Further objection to Y/35/26/PL. Demolishing existing caravan and replacement with 1 number dwelling, sited at the front of Little Meadow, Bilsham Rd., Yapton, West Sussex, BN18 0JY

OBJECTION

a). Addendum to Previous Objection: Technical Refutation of new Drainage Evidence.

Drawing Code	Drawing No.	Rev.
000-BPC-WD-ZZ-D-C	PL007	P01

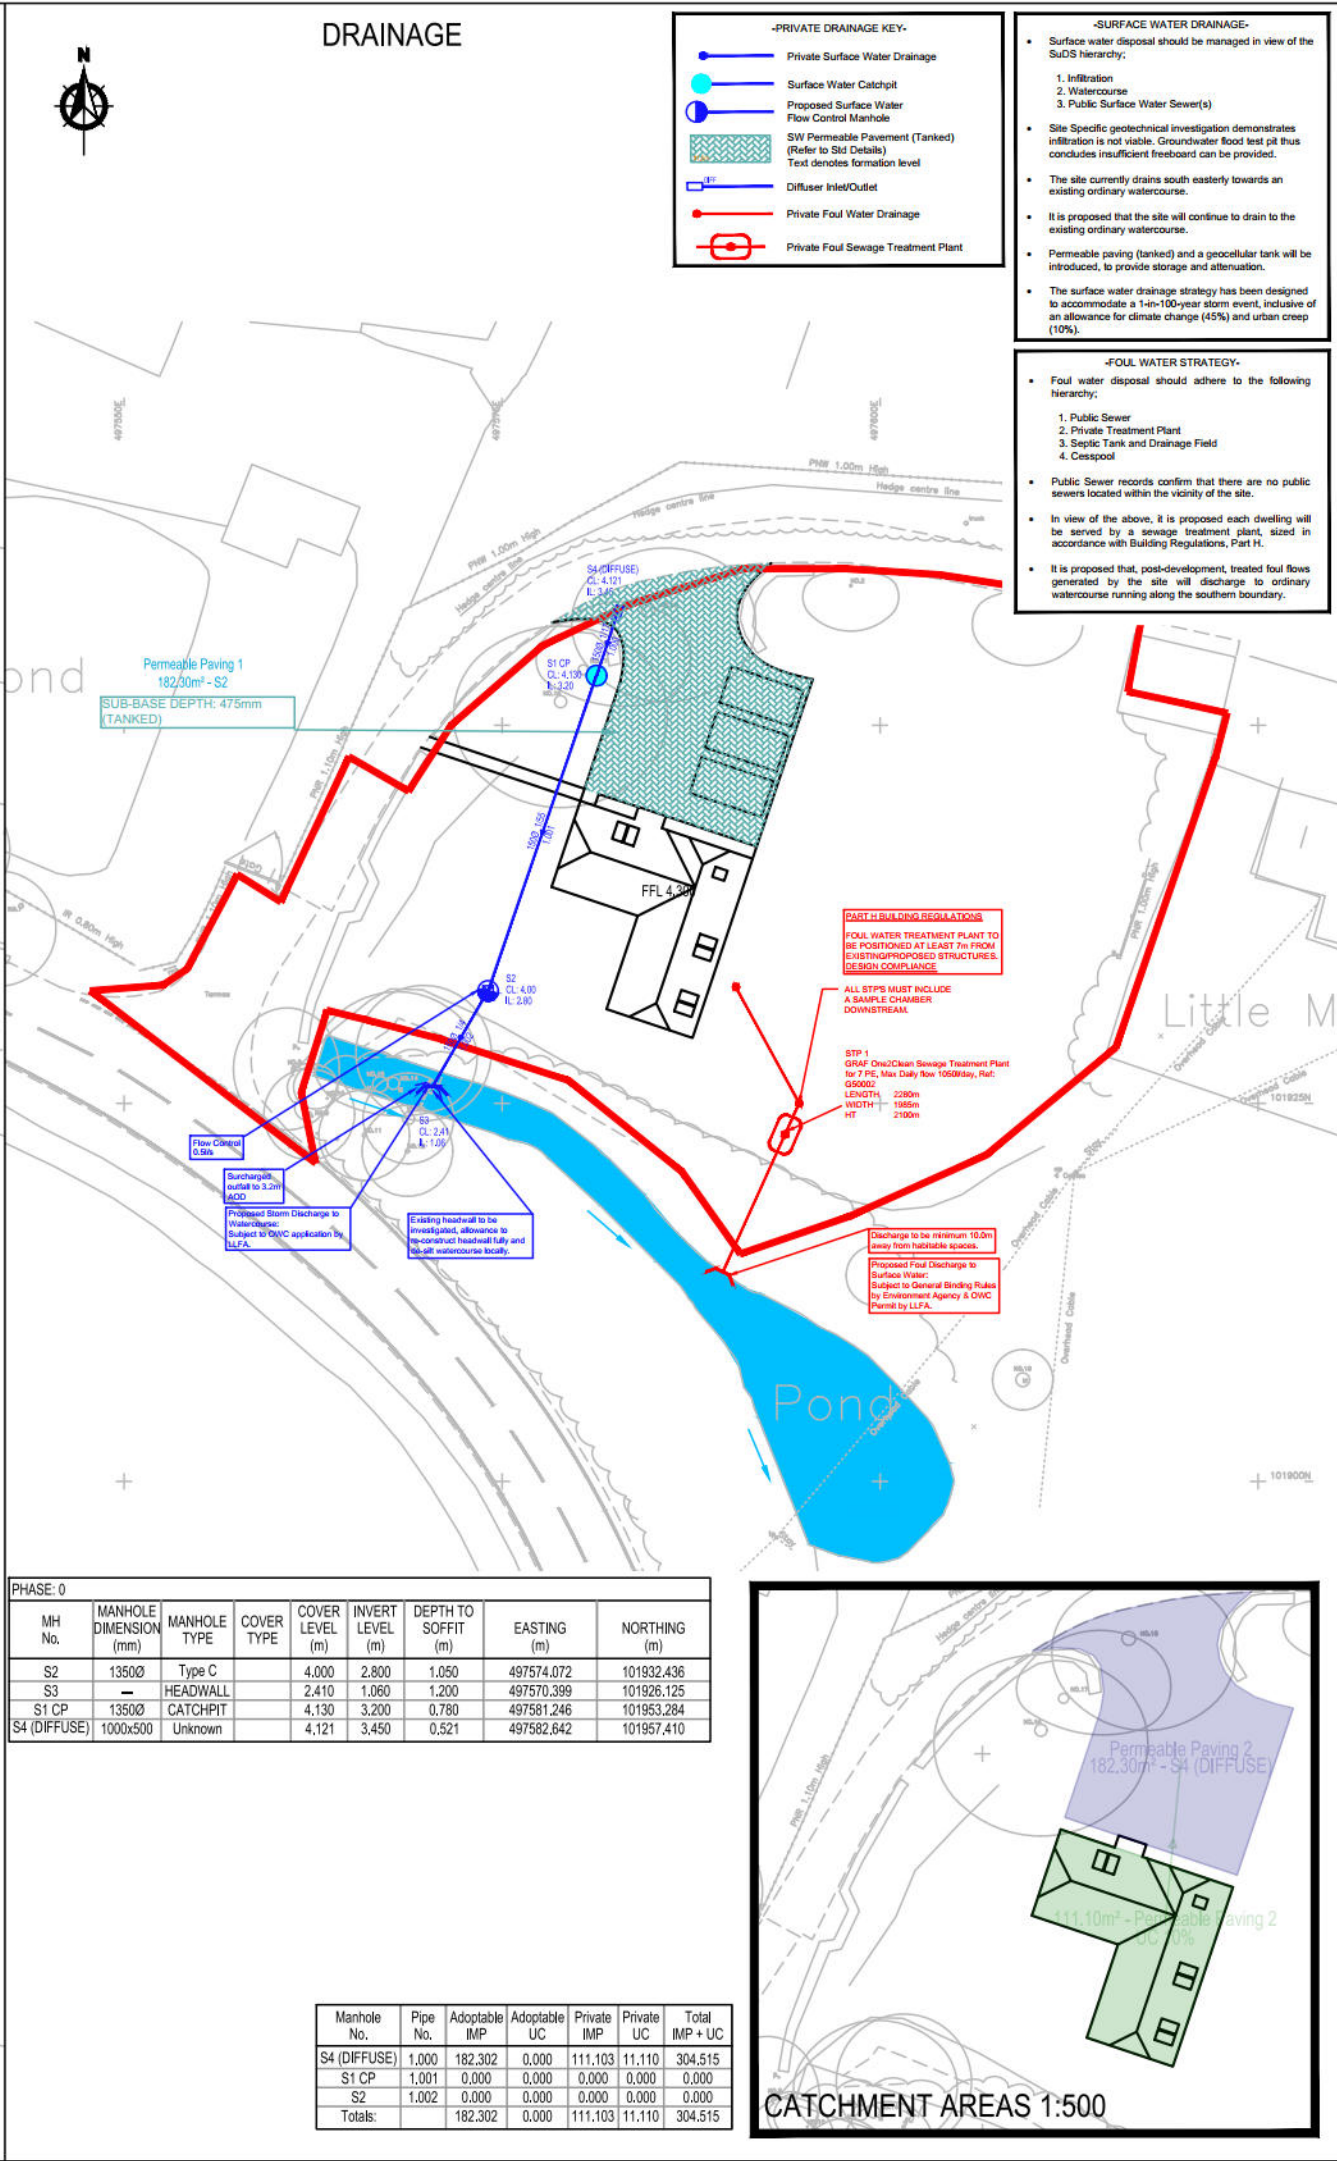
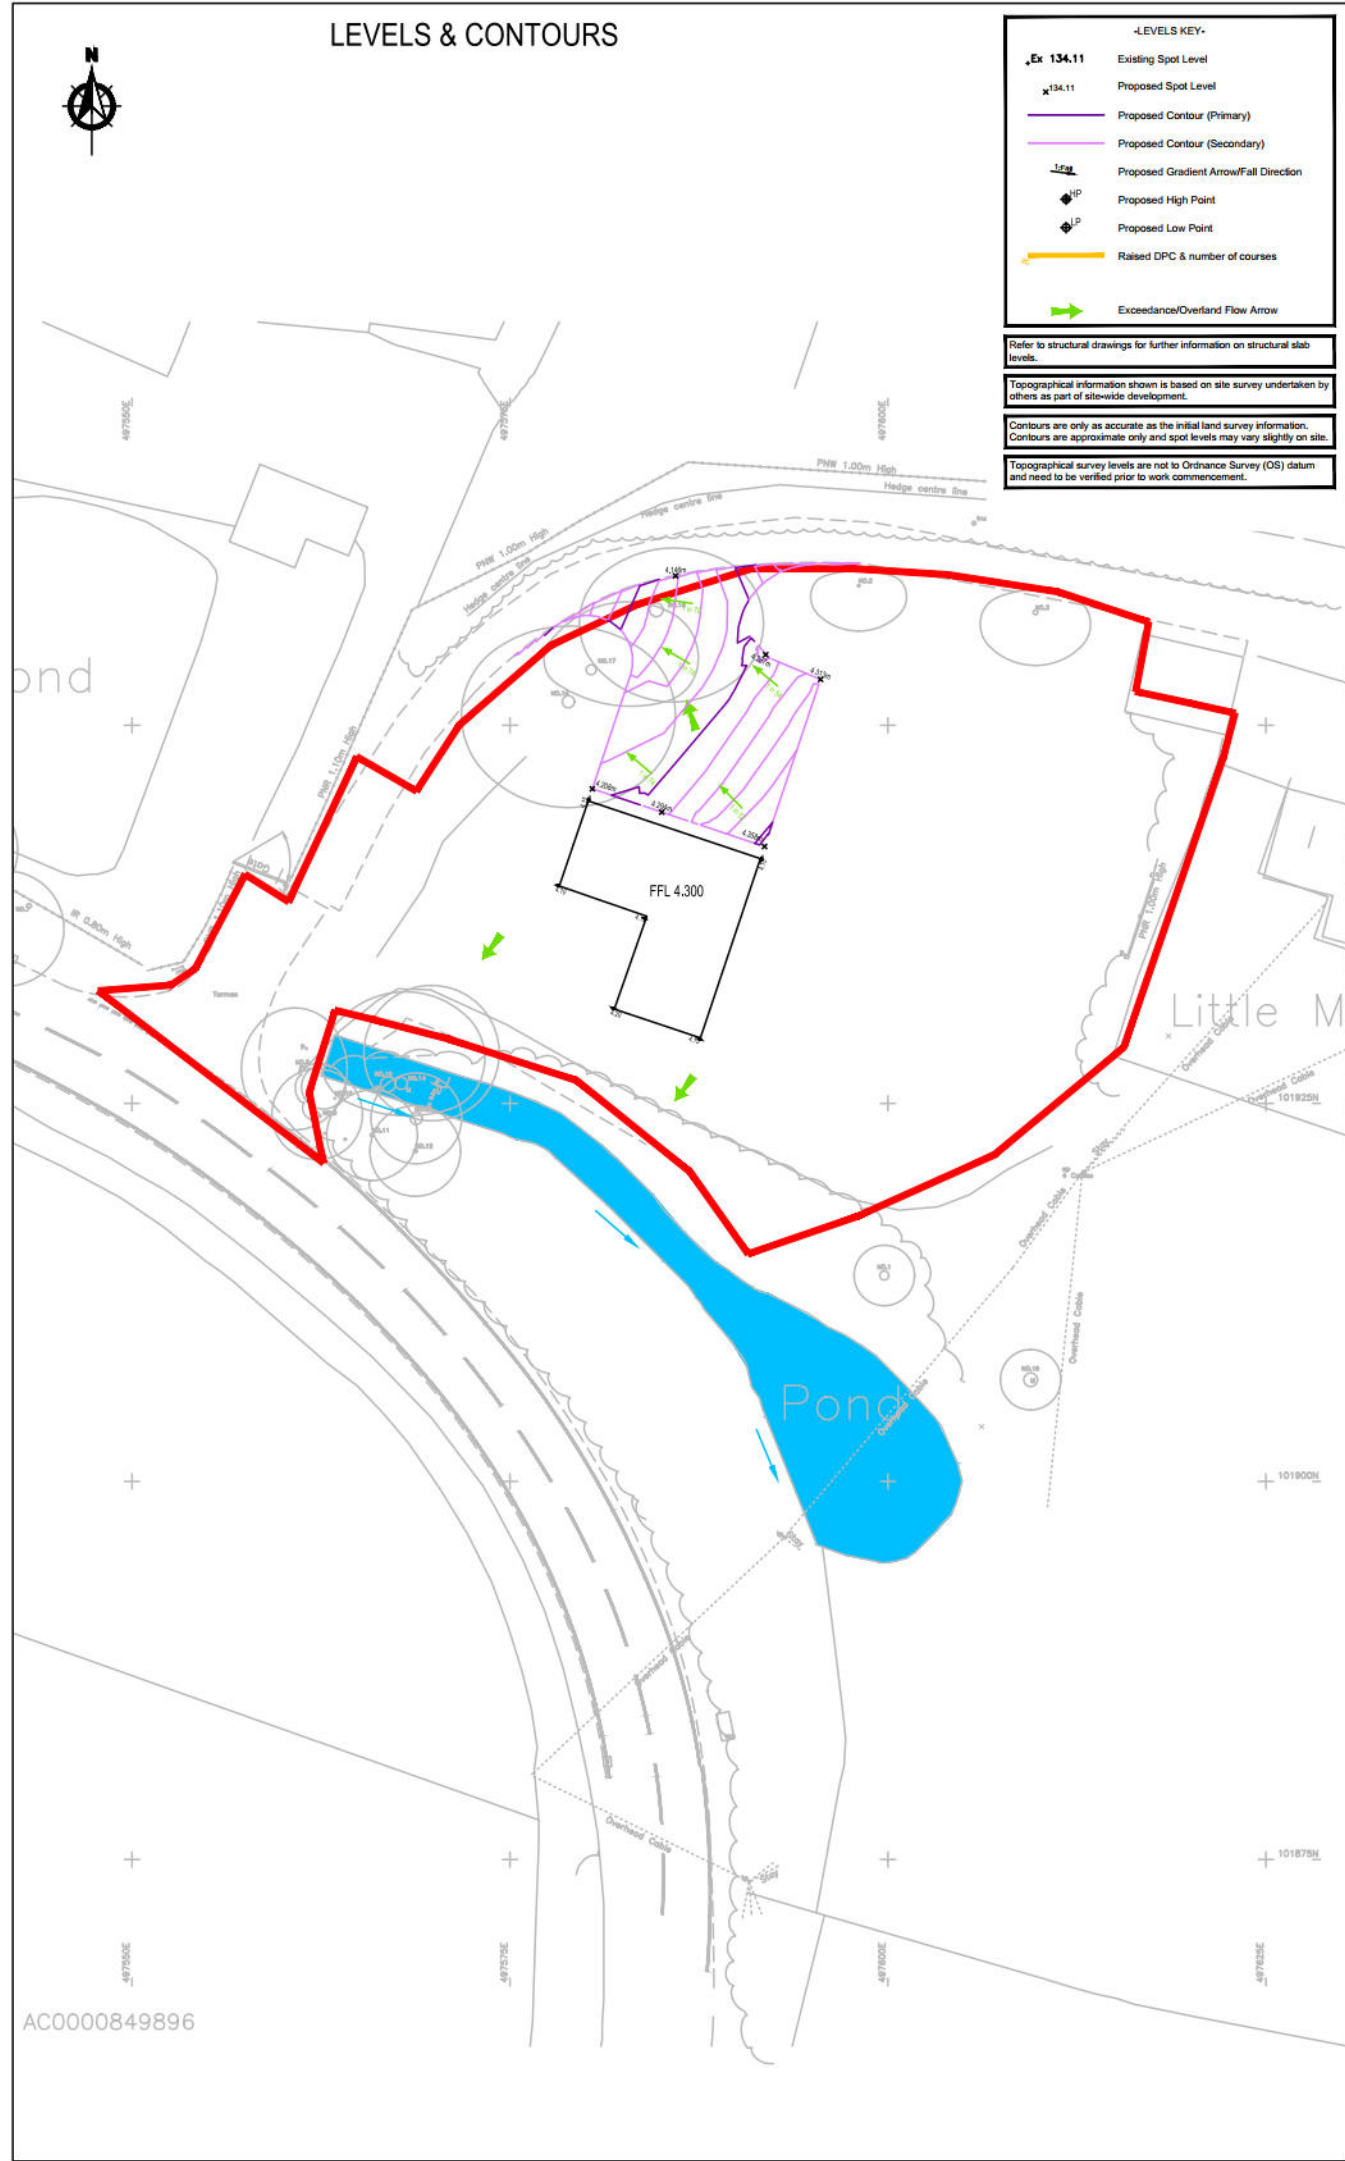
a) The run-off water/sewerage effluent from the package treatment plant is also allegedly indicated will be directed into the 'water course' (pond) on site. The consultant report acknowledges that this will have to be 'further investigated' as a 'pipe' was found and a 'head wall,' (Where exactly?)

b) The submitted plans show that the pond is blocked off. Unless there is proof of flow of an in- and- out, in a year -round aspect, such facility is considered a 'dry ditch' and unsuitable. It could also flood locally in its own right in winter.

a) The Claim: The applicant's consultant allegedly states that treated effluent will discharge into a watercourse.

b) The Reality: The reference feature is a dry ditch/enclosed pond with no recognised/evidenced continuous flow, as indicated above.

bi) The Violation: - Under the Environment Agency General Binding Rules discharging treated sewage into a dry ditch, pond or stagnant water body is strictly illegal. To discharge legally without a complex bespoke, legal permit, the water must flow through the entire year. The consultant is allegedly proposing a prohibited, unlawful, discharge method.

d) The Failure: If the water table is 0.7m, a 1m. freeboard requires the system to sit above the actual water level. **Furthermore, a package treatment plant, of the scale advised has a physical depth of approx. 2.0m to 2.3m. This means that 1.6 meters of the tank will be permanently submerged in water.**

di) This creates immense hydrostatic lifting pressure. Without unmapped, massive underground concrete anchoring, the tank will experience a catastrophic 'pop out' failure' rupturing the 500mm or 600mm house inlet pipe and rendering the house sanitation entirely inoperable.

Appendix A Development Proposals

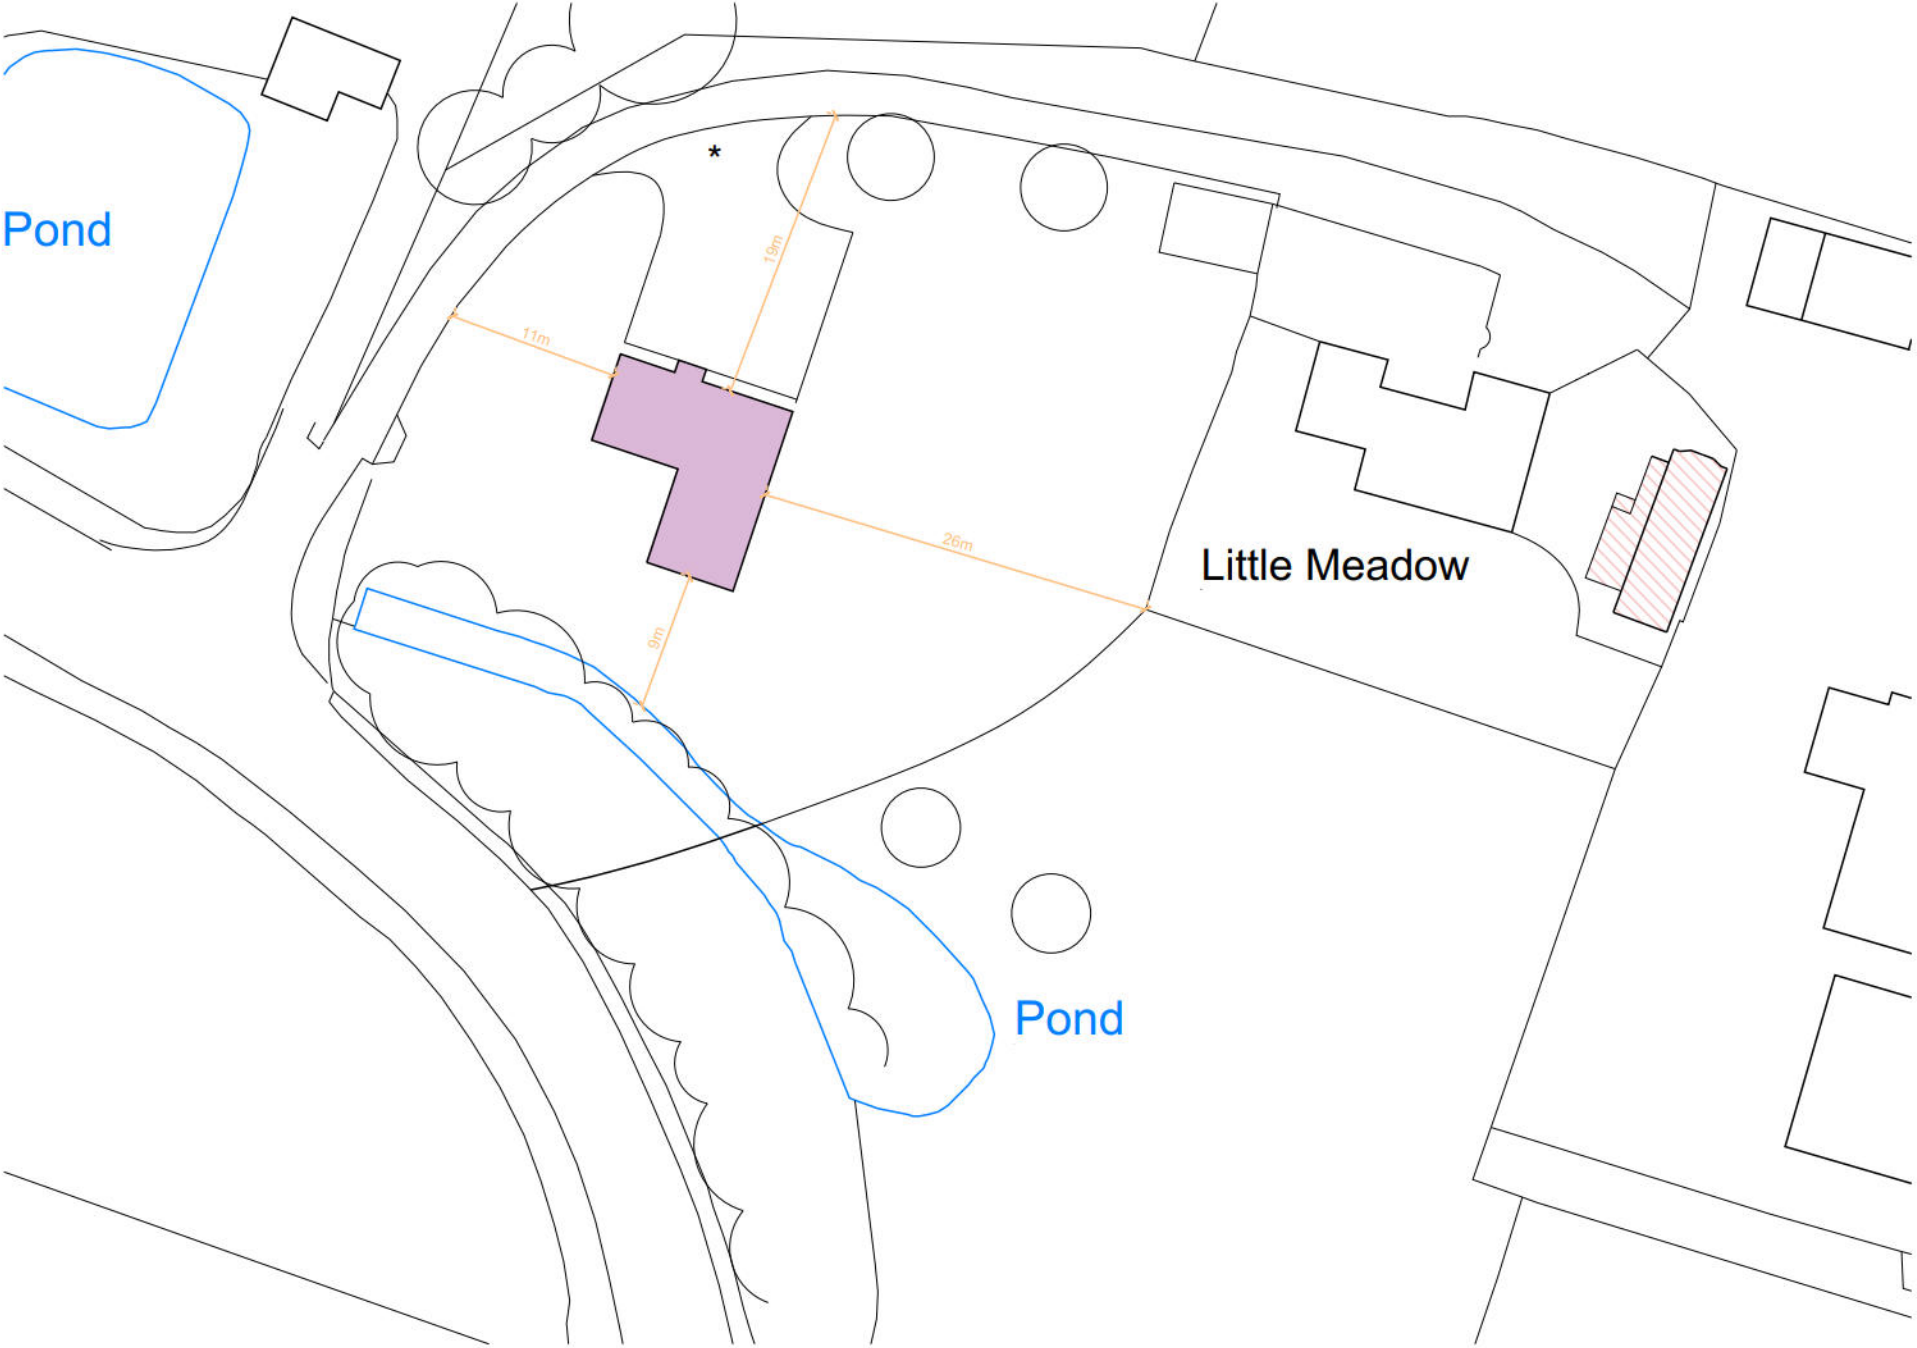
a) The Applicant submitted their original Location/ Block Plan on 16/6/2026- Ref.1805/DP01 REV01, which shows the proposed entrance to the site as to the **West** of the existing driveway.

On 29/6/2026 the Applicant submitted an alternative, 1805/DP02 which shows the entrance to the **North** of the site.

BP Civils submitted Flood Risk Assessment revised on 14/8/2026 which showed the site entrance to the **North**.

b) The decision to change the layout and drainage position details reflect on any package sewerage plant system (none allegedly shown as specific on the original or the revised block plans).

bi) Layout changes can be advised, but ancillary matters cannot be assumed when a property is moved to another area of the site. Levels and soils may be different, pipework, traffic, parking and new vehicular access to the Northern aspect may also need to be reviewed again by Highways and Ecology.

Furthermore, the Land Science and BP Civils Layout/Block plans refer to different areas on the site; the former with an entrance to the West and BP Civils with an entrance to the North and matters in association.

TITLE:	Existing Site Plan	REF:	LS9190	PREPARED:	JM
PROJECT:	Land West of Little Meadow, Bilsham Road, Yapton, Arundel BN18 0JY	FIGURE:	2	CHECKED:	MR
CLIENT:	Ross Hyams	DATE:	26/03/2026	VERSION	V1

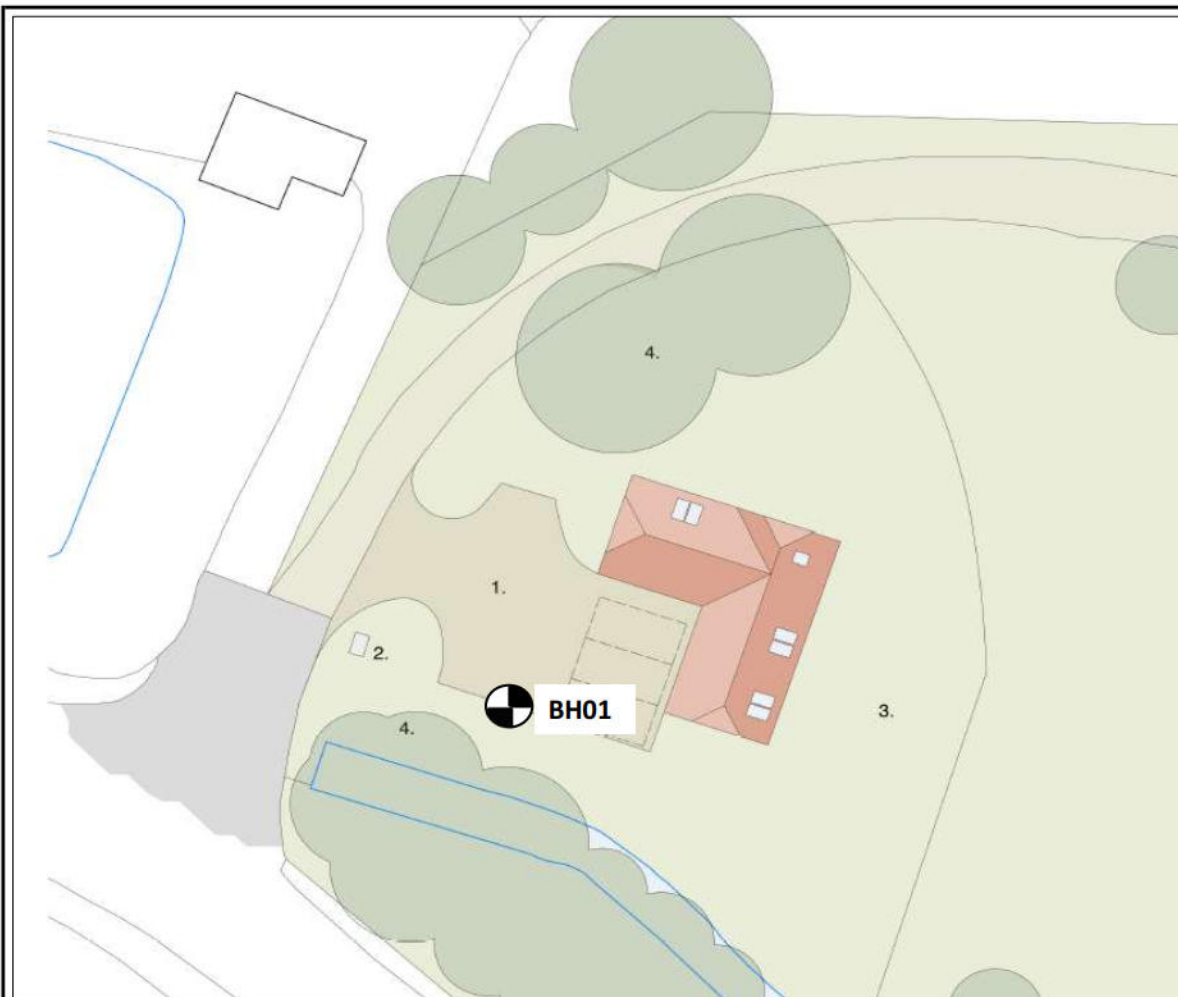
ai) Land Science submitted their details under Winter Groundwater Monitoring including a site Location/Block Plan on

16/6/2026, which showed the site entrance to the **West** of the driveway.
